NC DEPARTMENT OF  
**HEALTH AND  
HUMAN SERVICES**

October 3rd, 2023

RE: Food Lion #2607  
1243 East Cumberland Street  
Dunn, NC 28334

This letter acknowledges review of the remodel plan for the above referenced establishment. The plans received on 07/12/2023 application, and specifications including email correspondence are approved with the following comments:

11 OF 45
A1.05
FLOOR FINISH PLAN

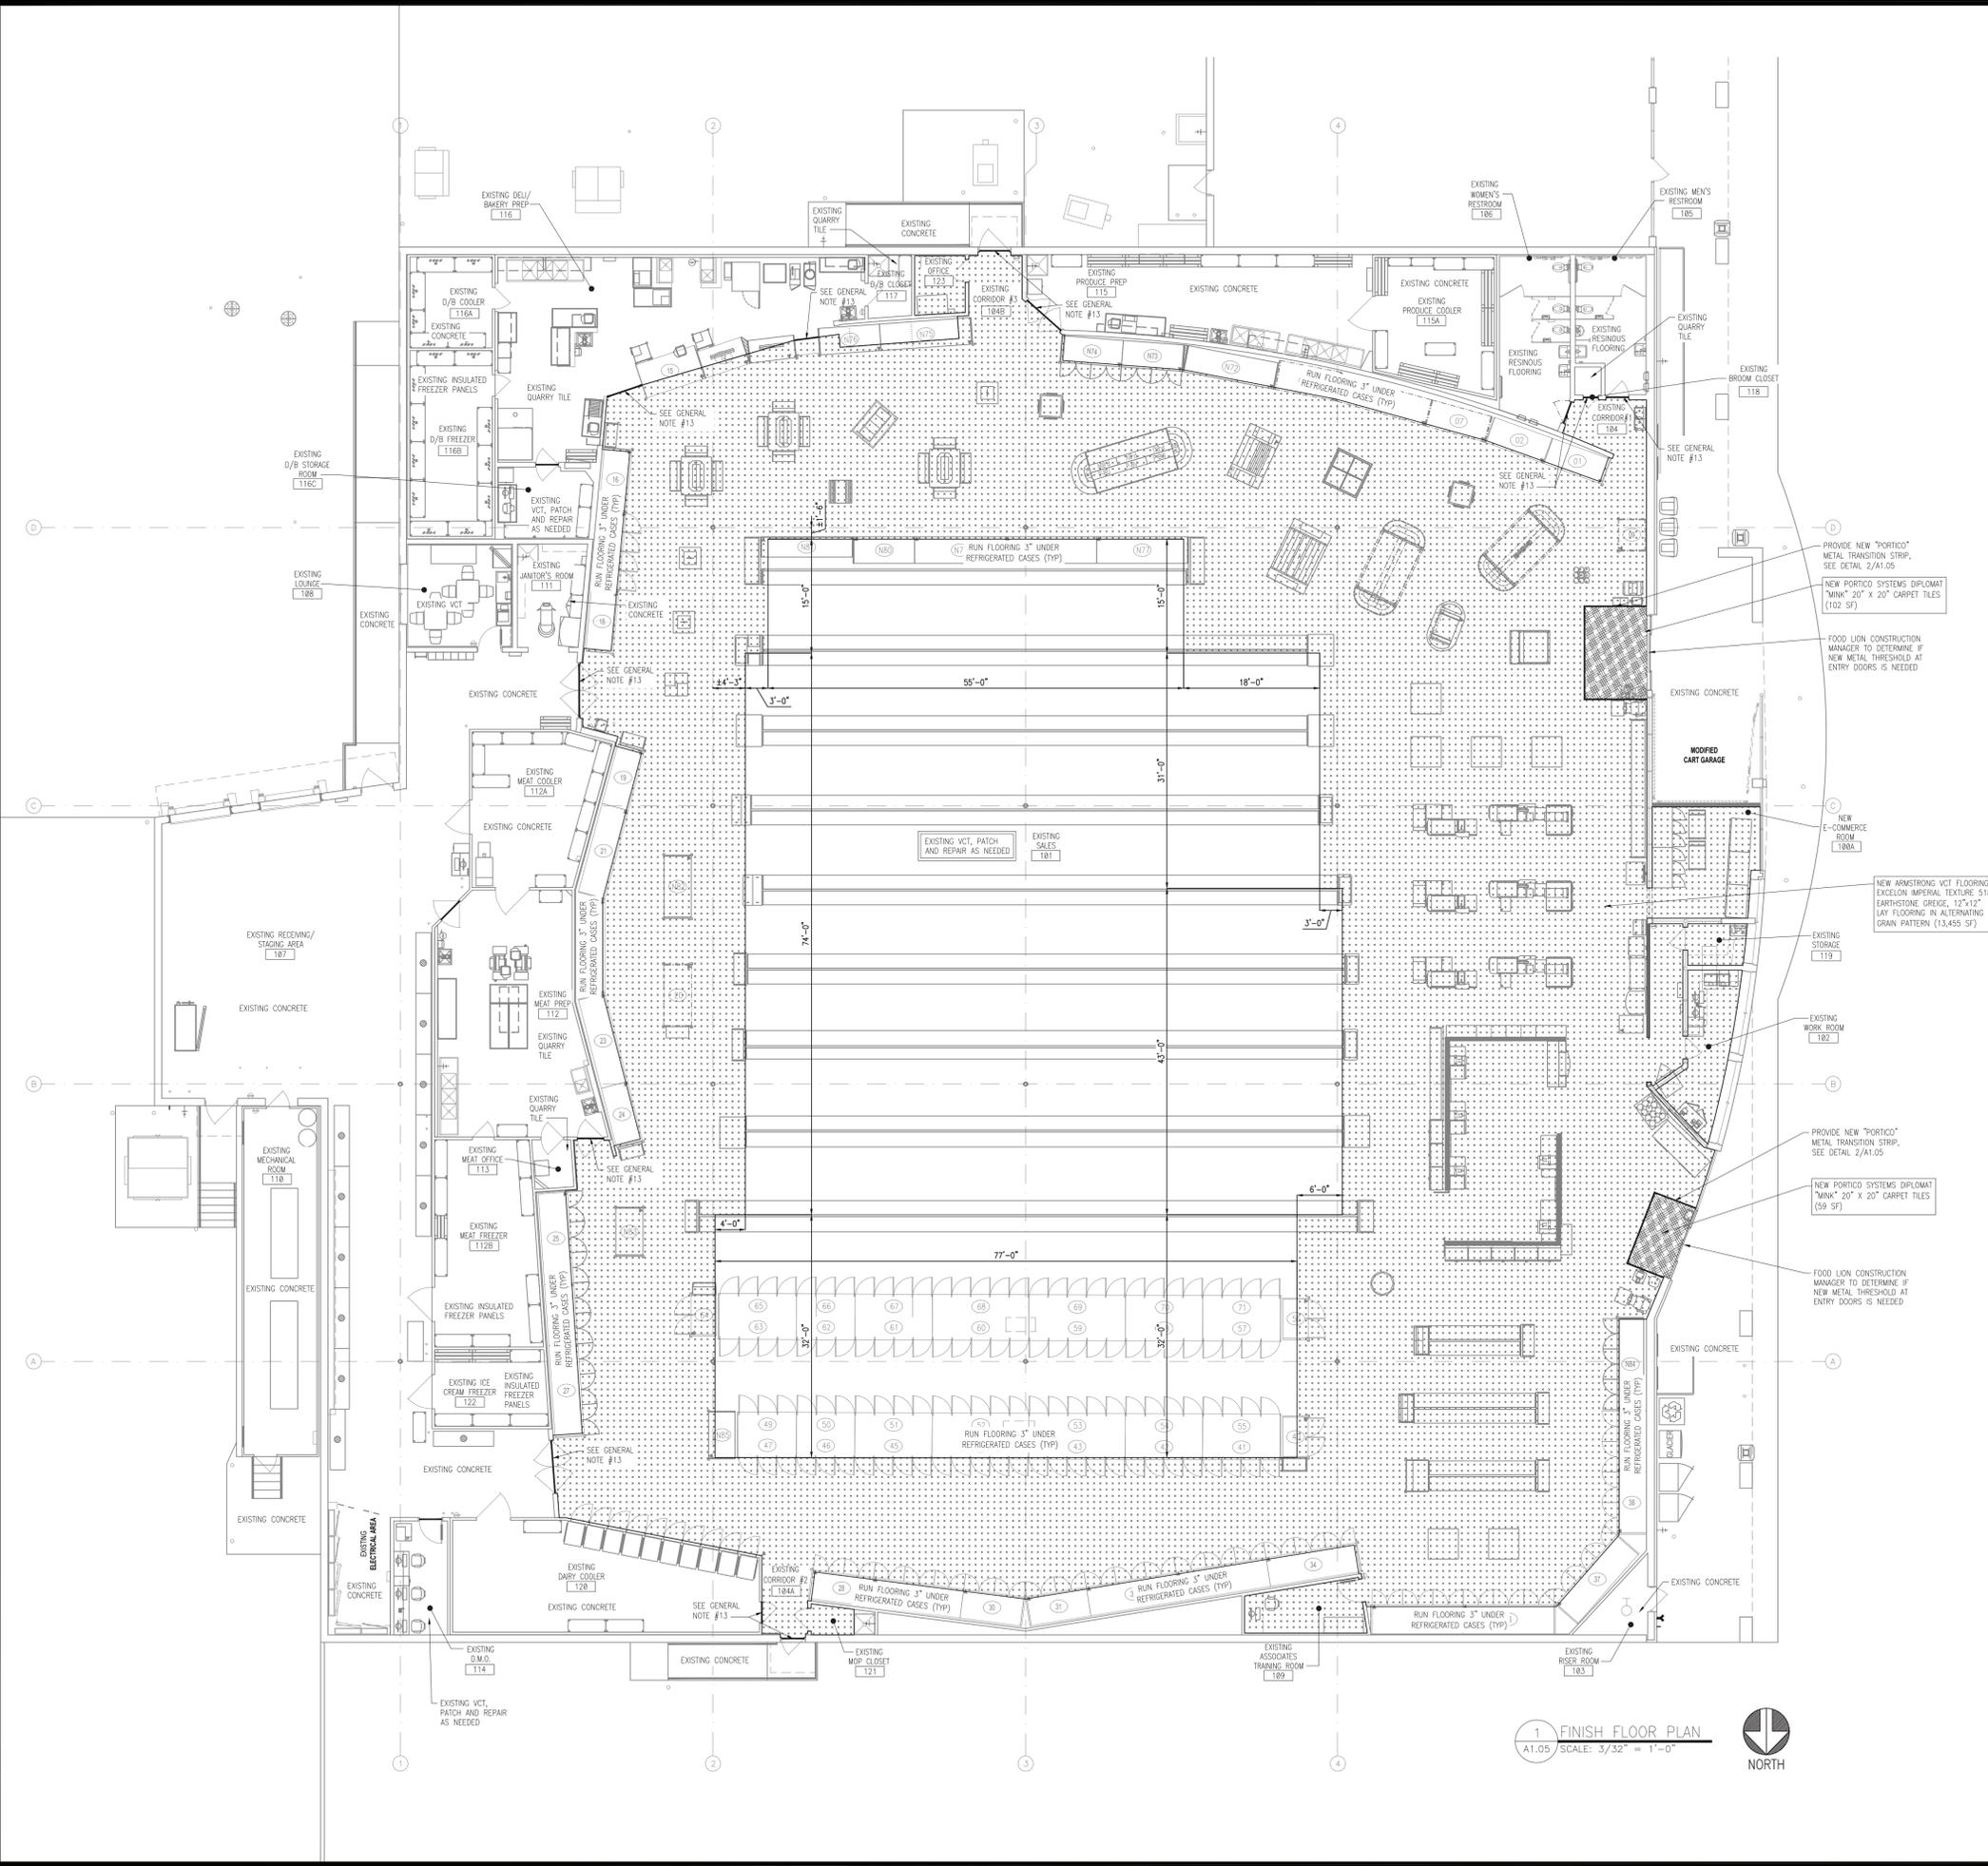
3. Any renovations and repairs to floors, walls and ceilings must comply with Subparts 6-101 and 6-201 of the Food Code. Existing finishes must be in good repair. New finishes must be smooth, durable, and easily cleanable for areas where food establishment operations occur. In addition, floor and wall junctures in all foodservice areas, walk-in coolers and freezers, and toilet room areas must be coved. Otherwise, the finishes as specified on the application are approved.

1 ENLARGED DELI/BAKERY EQUIPMENT PLAN
A4.01 SCALE: 1/4" = 1'-0"

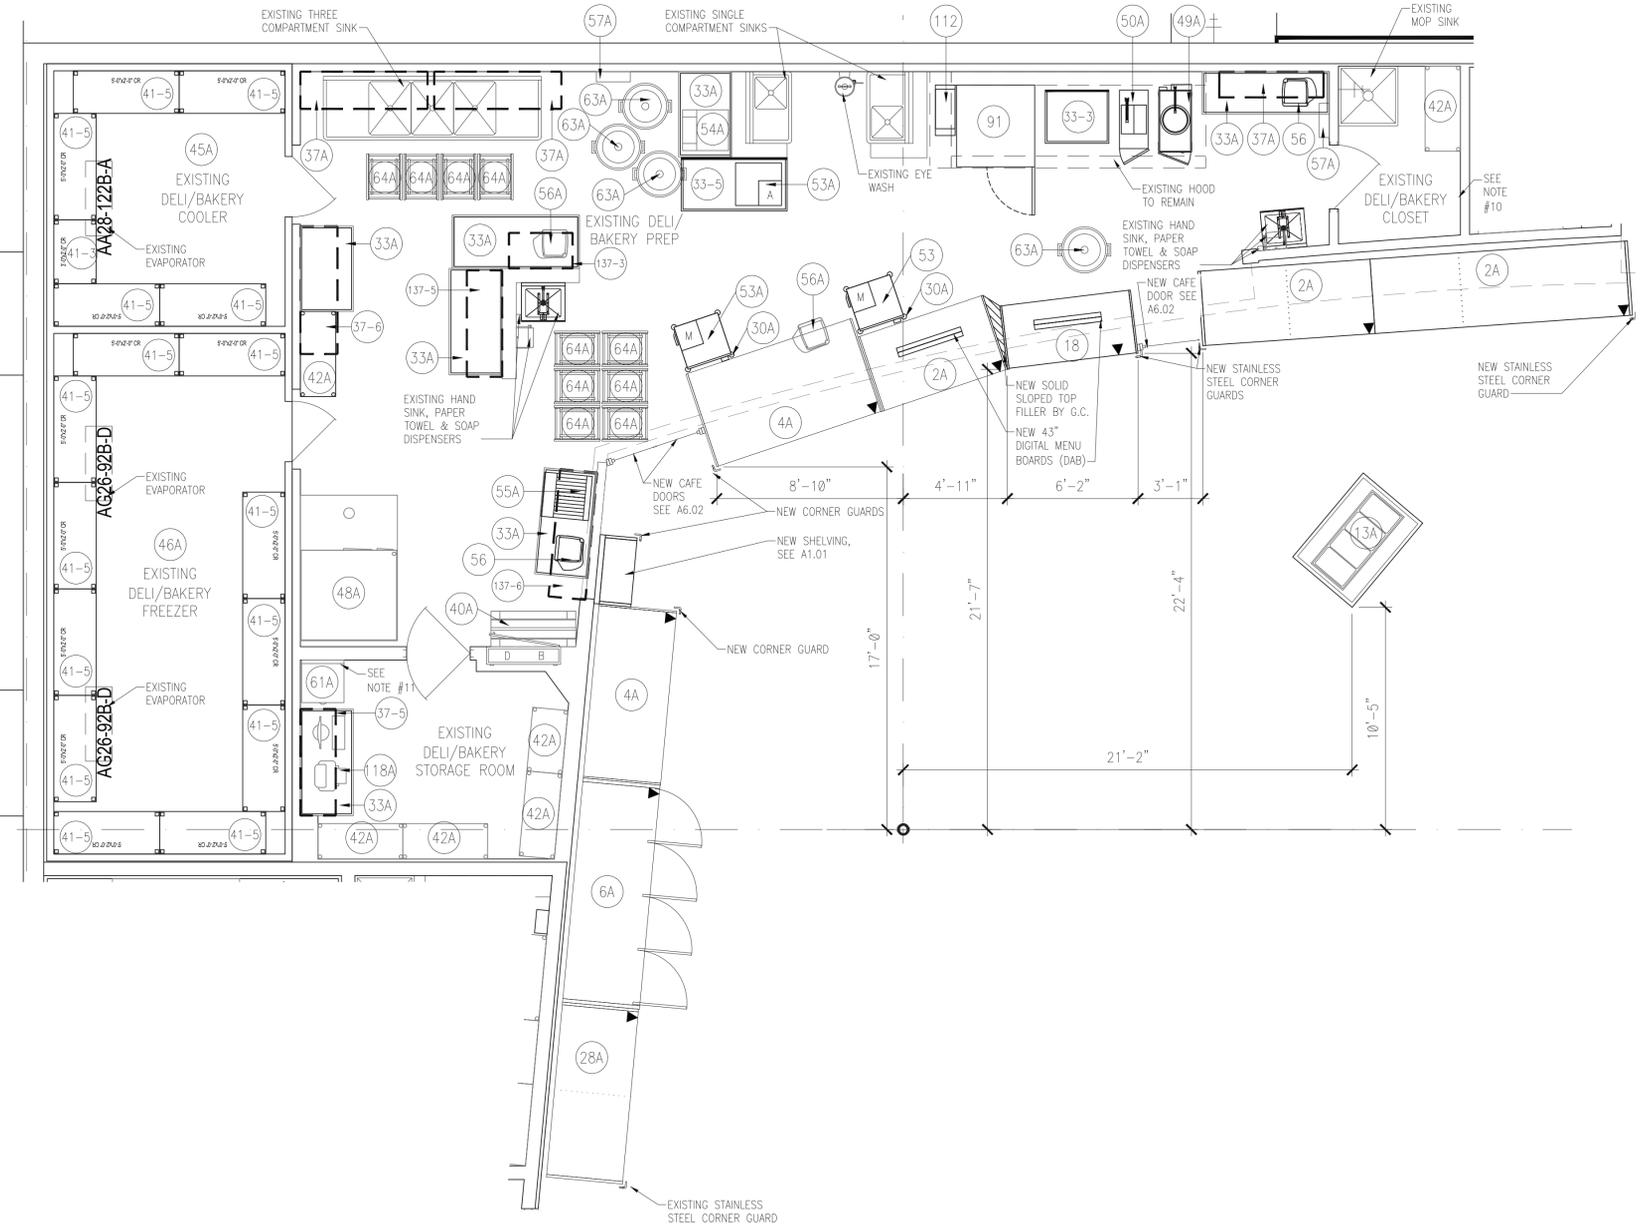
1. The scope of work covers the addition of new equipment in the Deli/Bakery Prep/Sales Areas with the installation of a new equipment including: (2) Stainless Steel tables, (5) Boat racks, (1) hot deli self-serve case, (7) refrigerated cases (17) shelving in cooler (2) scales (8) display tables (1) shelving rack and (1) Combitherm oven and cart. The combi-oven will need to be installed under the hood in accordance with local building code, as well as meeting all requirements in the equipment specification sheet. In addition, equipment will be removed and relocated as part of the remodel as indicated in the supplied SCOPE of Work.

2. Updated food equipment must comply with Section 4-205.10 of the North Carolina Food Code and be installed as specified in Sections 4-402.11 and 4-402.12. The grinder in the Meat Department will be relocated from the existing Meat Prep area, into the Meat Department's walk-in cooler. All other existing equipment, and fixtures remain approved, and with this understanding; the revised fixture plan is approved.

1 SANITARY SEWER AND DRAIN PLAN
P1.01 SCALE: 3/32" = 1'-0"
NORTH

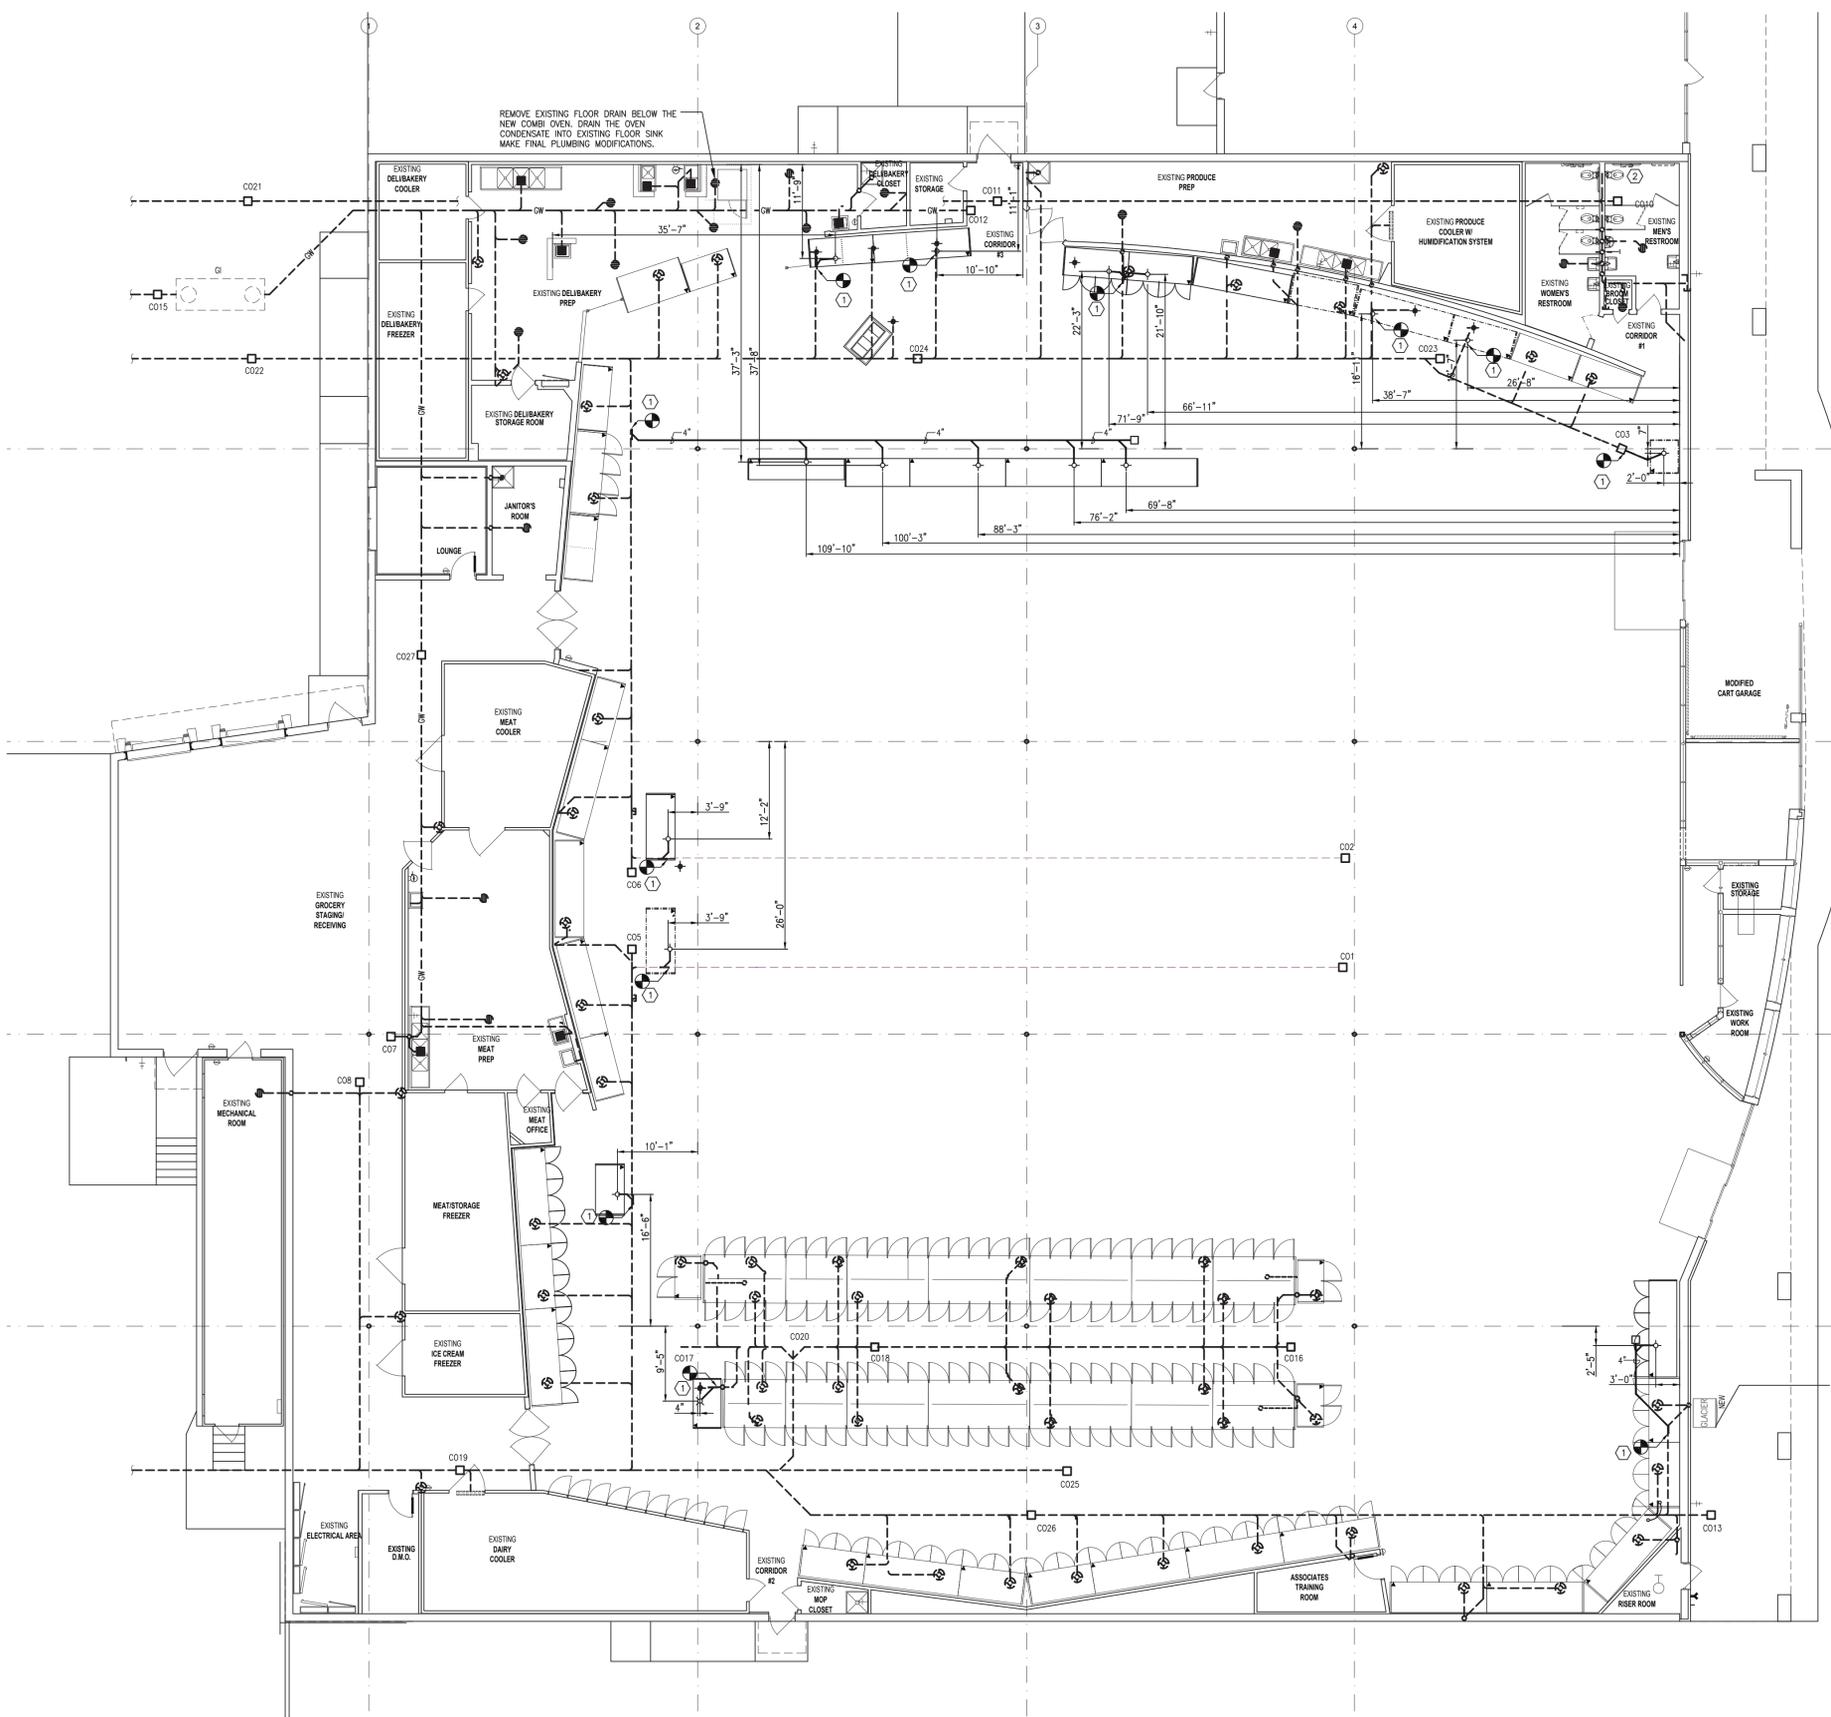
4. The existing Sanitary Sewer and Water Piping plans are approved for continuous use. The hot water heating system supplied as specified is also approved for continuous use. The existing water heating system is acceptable if it is sufficient to meet peak hot water demands. If it does not, the hot water system will be modified, and/or replaced to meet hot water requirements.
